Ann Machado - 467 Danforth Street - Permit #2013-02805

From: Ann Machado
To: adam@mastconstructioncorp.com
Date: 1/9/2014 9:45 AM
Subject: 467 Danforth Street - Permit #2013-02805

I have completed my zoning review and at this point I cannot sign off on the permit.

CVR

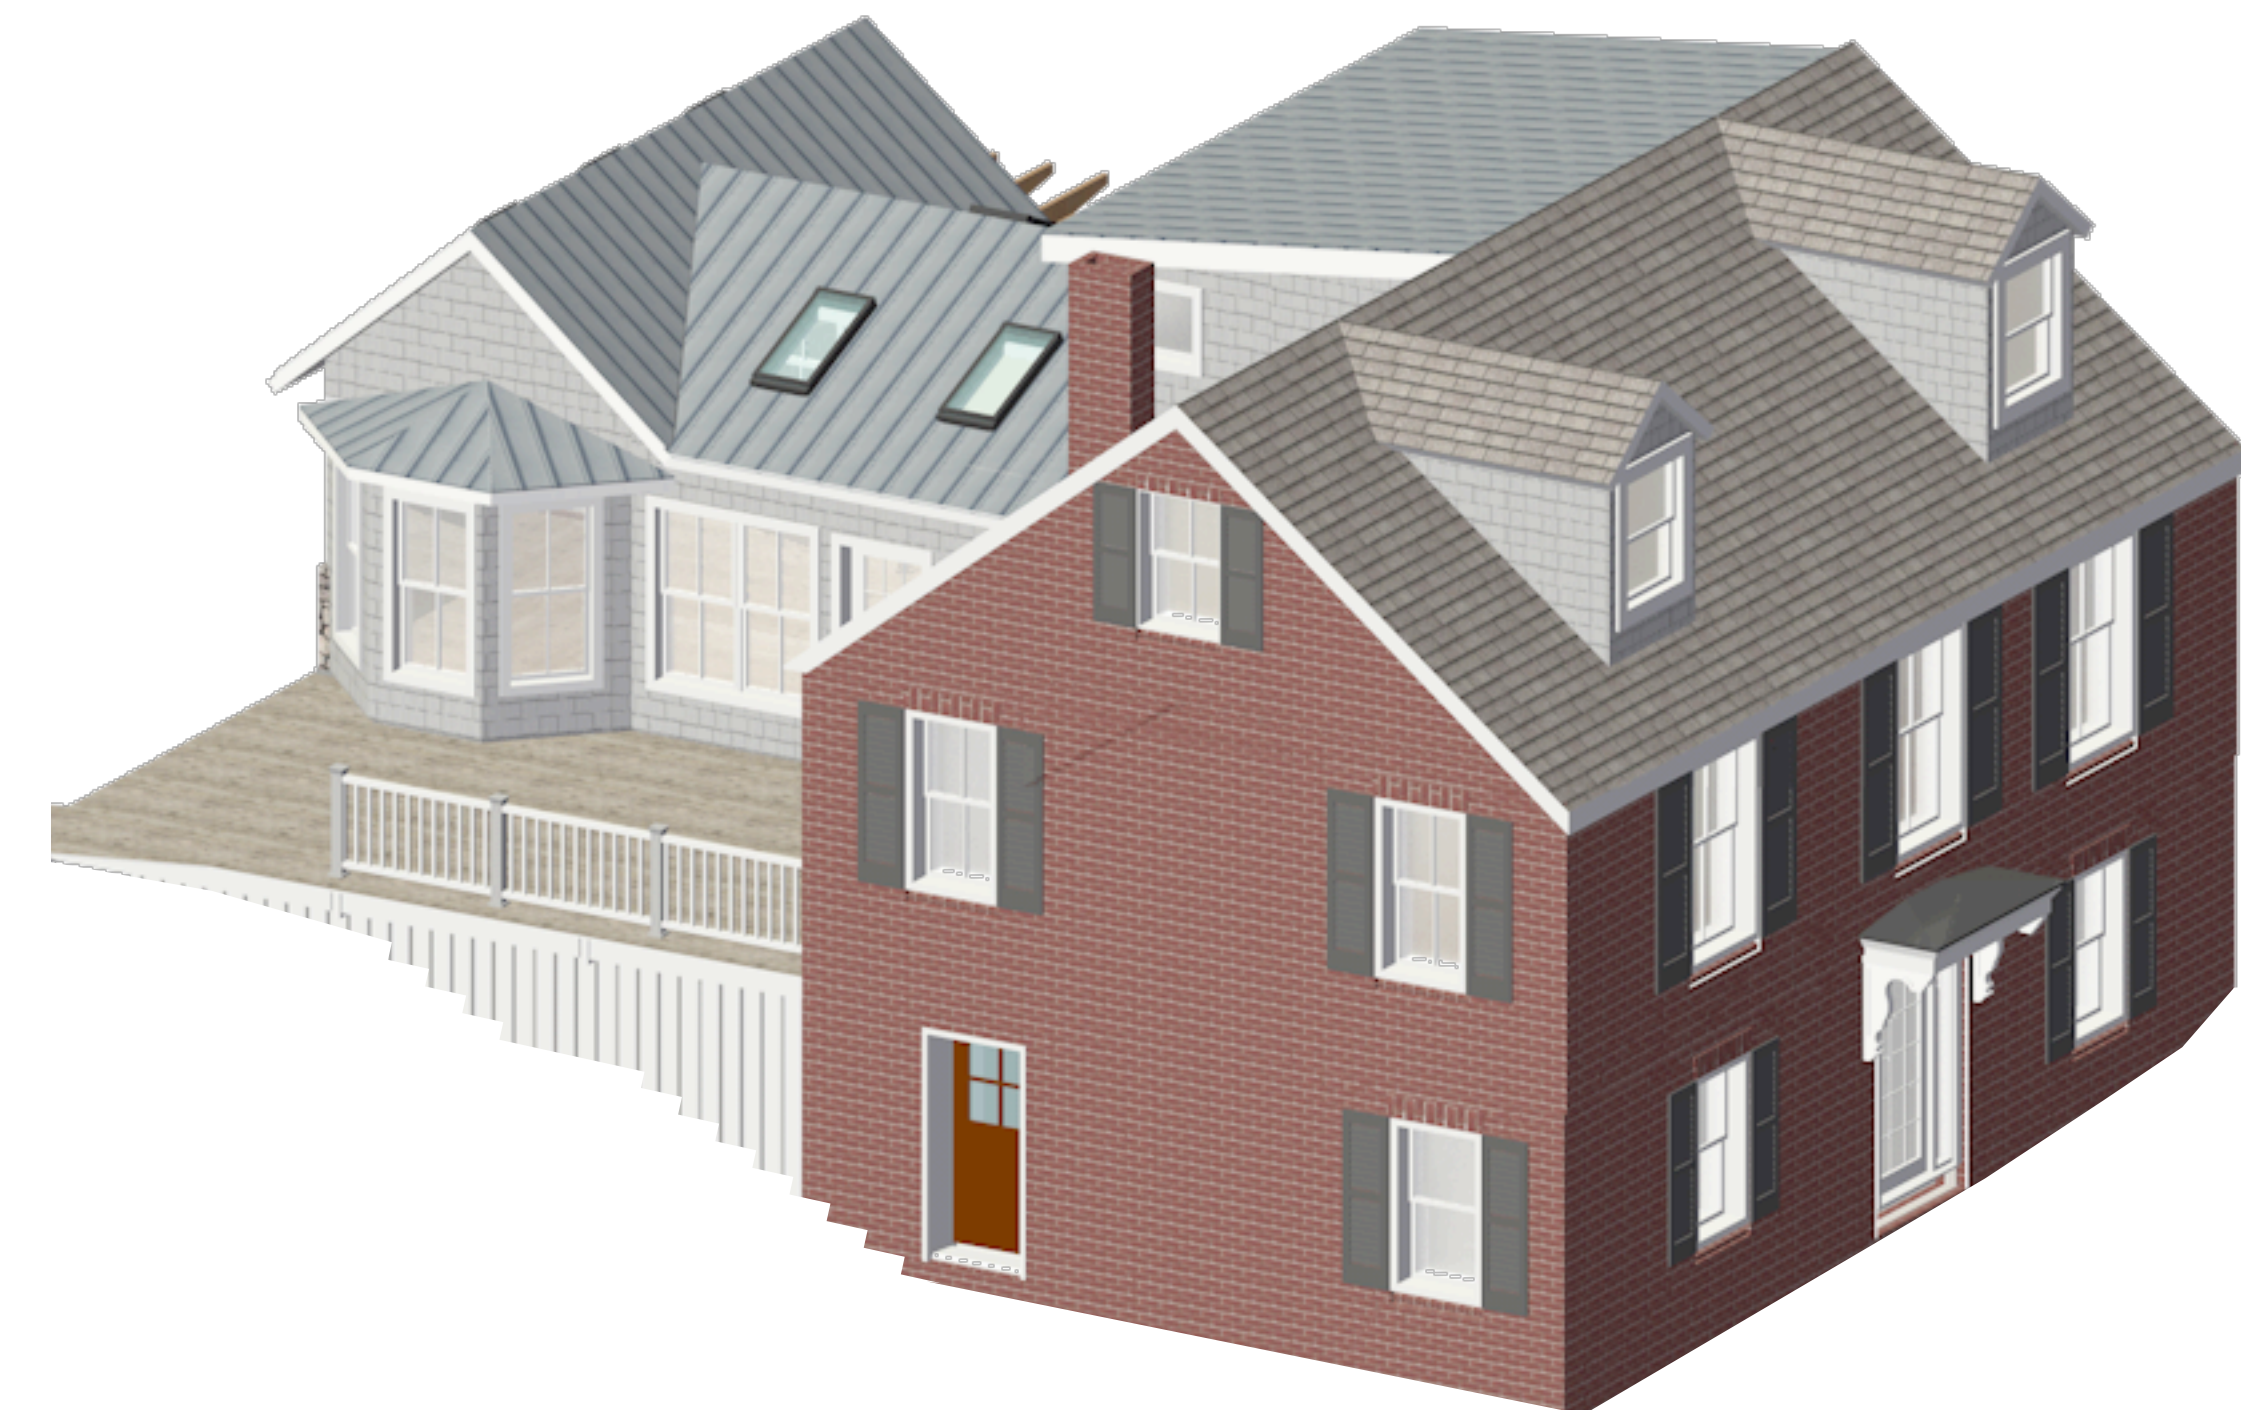
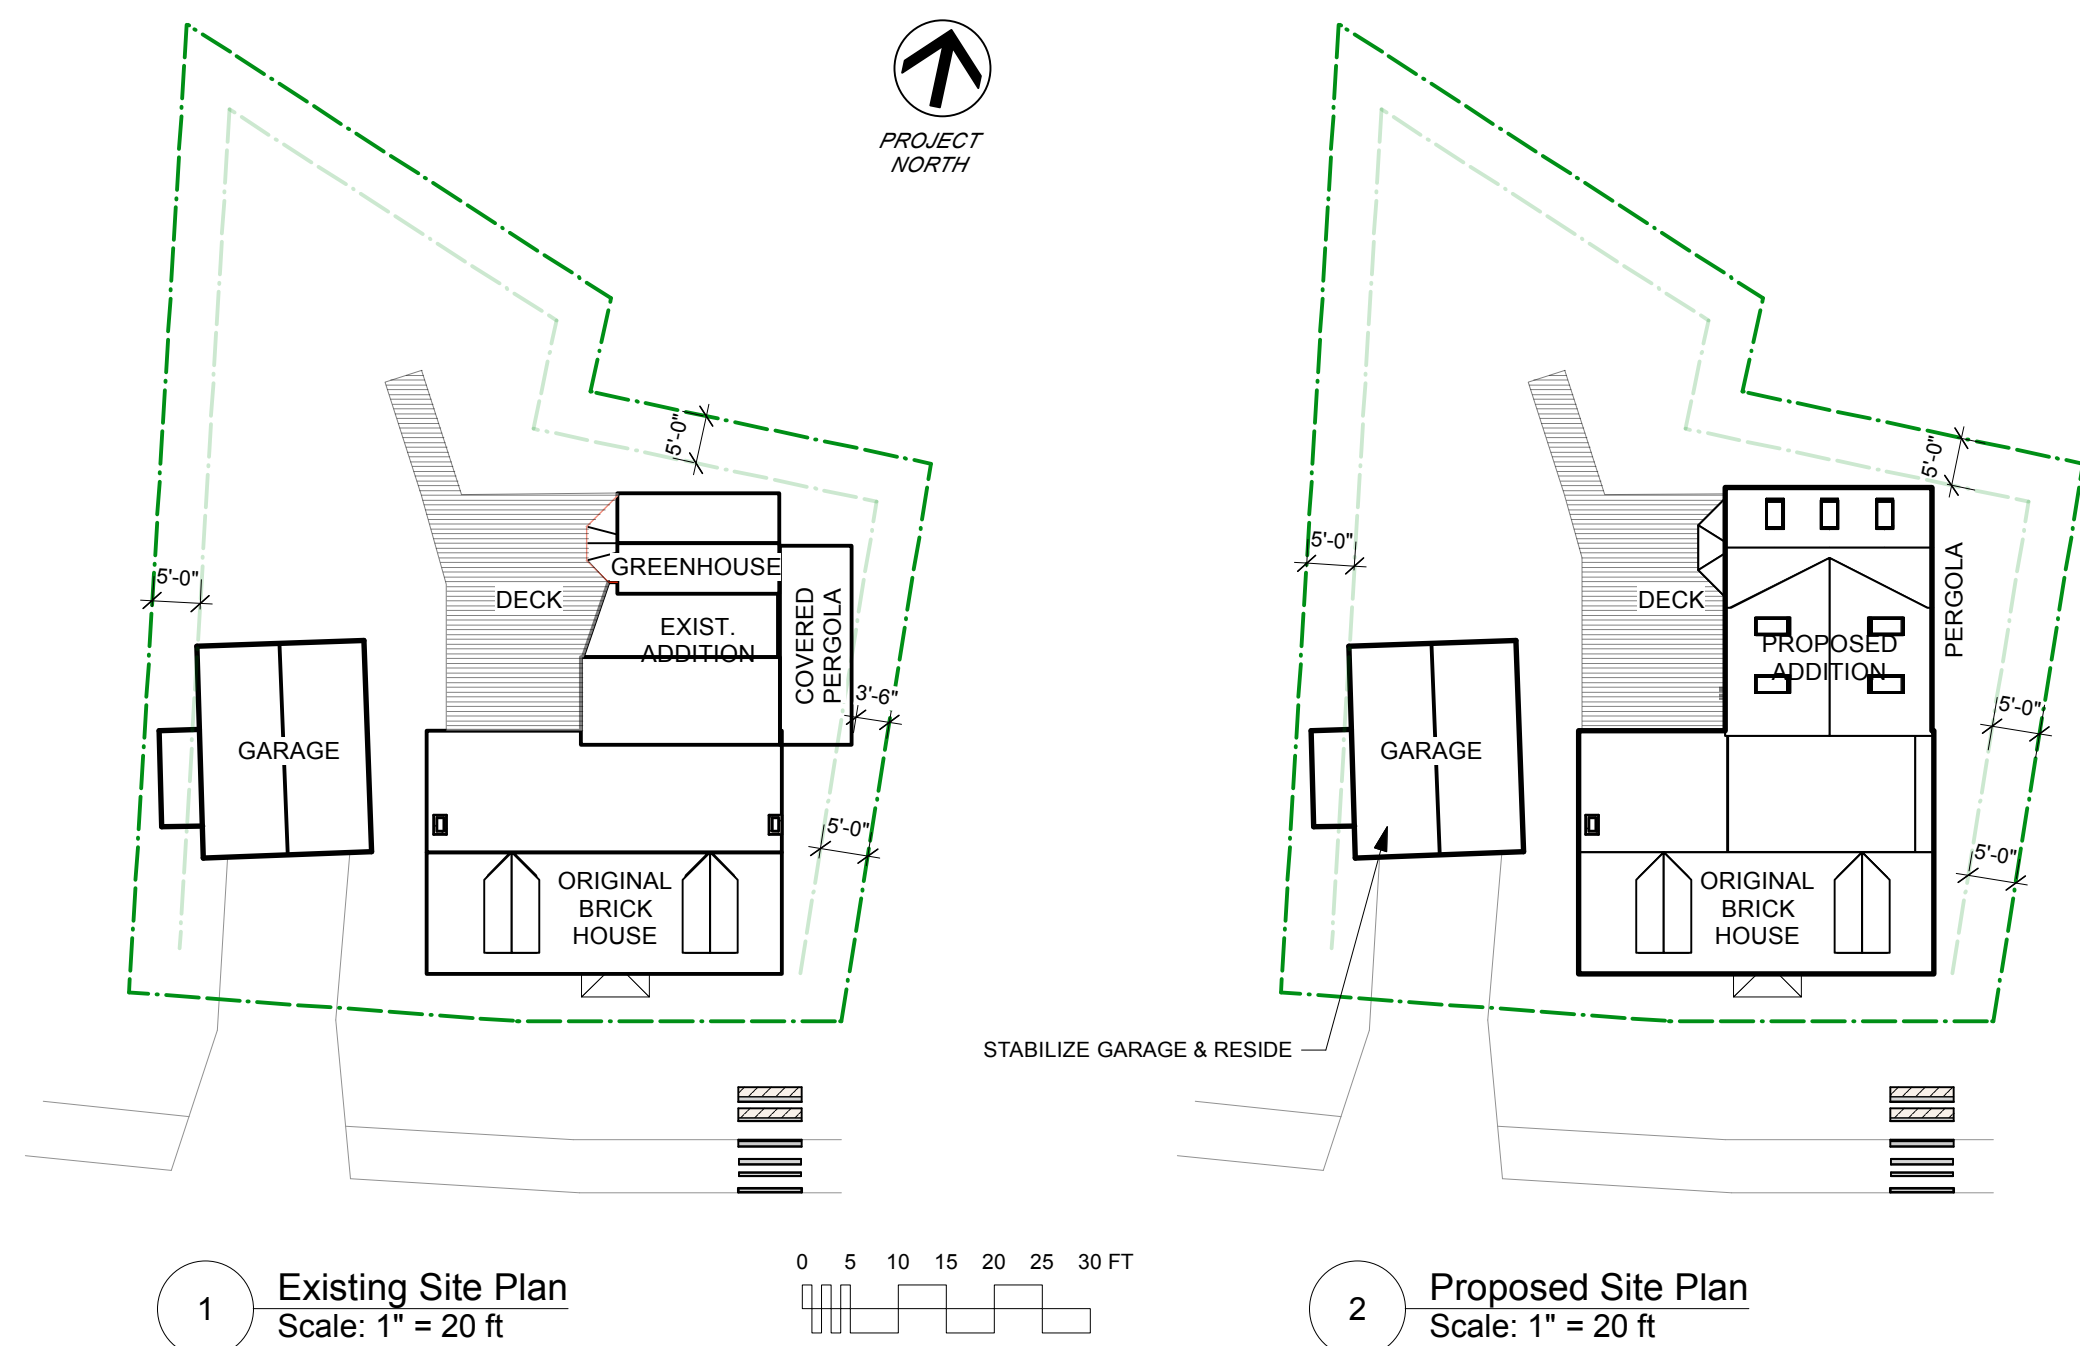
3. I researched the permits that we have on file for the property and I could not find a permit for the deck and the rear addition that is being removed. If there is not a building permit the structure is not legal. The footprint of all the existing structures as shown on the existing site plan add up to more than the allowable 30% lot coverage. 30% lot coverage = 1786.2 sf. When I scale the main building, the deck and the garage I get a total of 2172 sf. Section 14-433 does allow the rear and side setbacks for an addition to be reduced if the principal building was built before 1988. The proposed addition can probably be built but the deck is going to have to be reduced to bring the lot coverage into compliance.
